Please find attached my Deadline 3 submission in relation to the Outline Construction Traffic Management Plan [REP1-055].

- An inconsistency in document referencing (Figure 2 vs. Figure 4.1);
- Ambiguity over the identification of roads with duplicate names in North and South Clifton;
- Concerns regarding the suitability of narrow single-track lanes in North Clifton for HGV or construction traffic; and
- The need for a clearer and larger version of the barred routes plan, showing village names and road labels.

Figure 4.1: Barred Route Plan

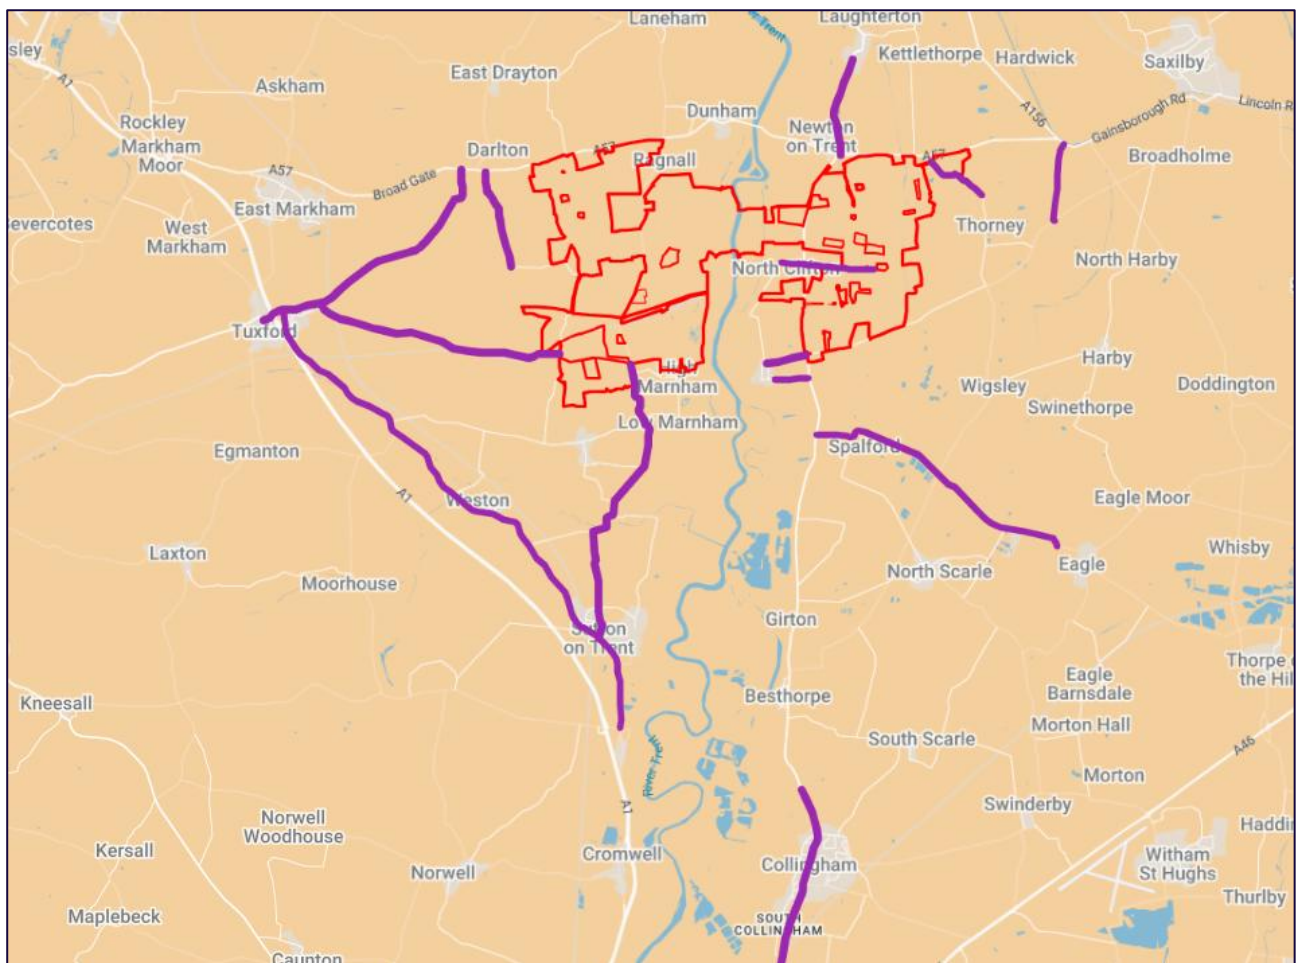
I respectfully request that the Examining Authority seeks clarification from the Applicant on these points and ensures that unsuitable roads in North Clifton are explicitly included within the barred routes.
